**RE: SADDLEHORN RANCH – FILING 1 – FIELD CHANGE NOTICE – DELETION OF CURTIS ROAD
DRIVEWAY CULVERTS**

Please consider this field change notice letter for the Saddlehorn Ranch –Filing 1, located in Section 3 and 10, Township 13 South, Range 65 West of the 6th Principal Meridian in El Paso County, Colorado. JR Engineering has produced plans adding a total of 5 driveway culverts (see attached exhibit) along the west side of Curtis Road which per plan is to remain a 2’ shoulder. The east side is adding a lane/shoulder for the entire length of Saddlehorn Filing No. 1. The 5 drives currently do not have culverts and virtually no ditch.

SHEET	7	OF	51
<div> <div>SADDLEHORN RANCH – FILING 1</div> <div>CURTIS ROAD – STRIPING PLAN</div> </div>			
H-SCALE	1"=50'	No.	REVISION
V-SCALE	N/A		
DATE	05/07/20		
DESIGNED BY	NQJ		
DRAWN BY	NQJ		
CHECKED BY			
JOB NO.	2514202

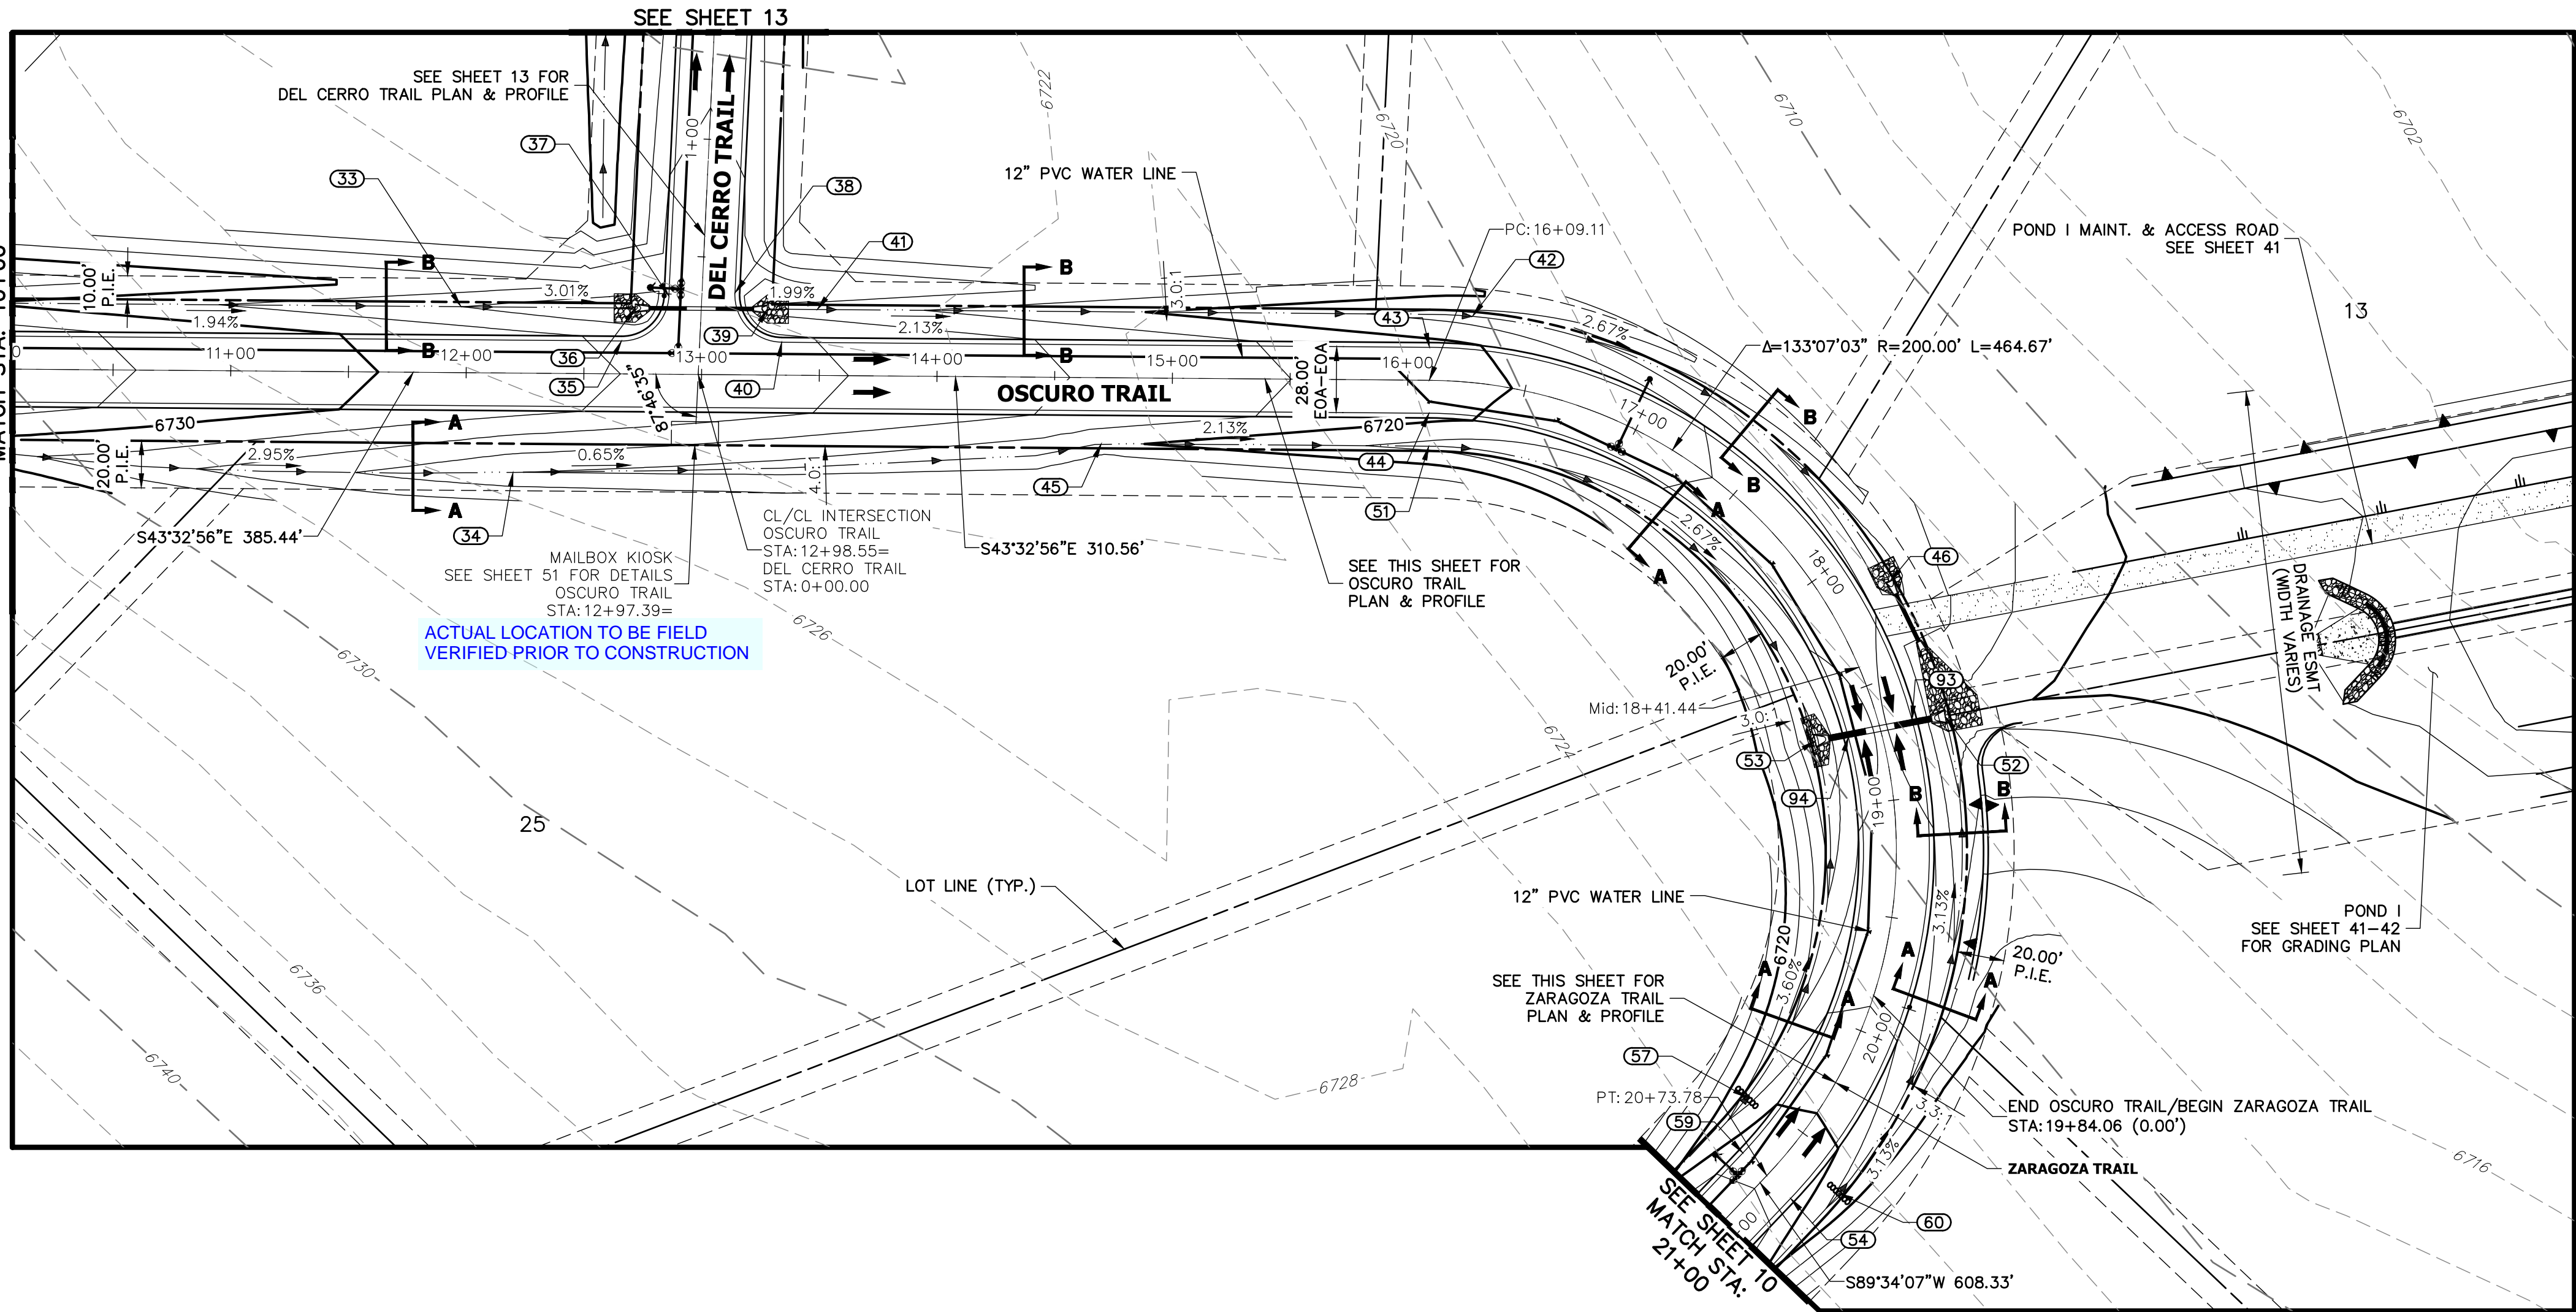
Given that the County will obtain ROW in the future along the western side of Curtis to complete the planned full roadway section (to fit a 8’ wide paved shoulder) and the disruption the work would cause to neighbors by adding the culverts and ditches, JR Engineering requests that the culvert/ditchwork be eliminated from the project. It’s anticipated the ditch work and driveway culverts would be added at that time the ROW is acquired and the road widened by the County.
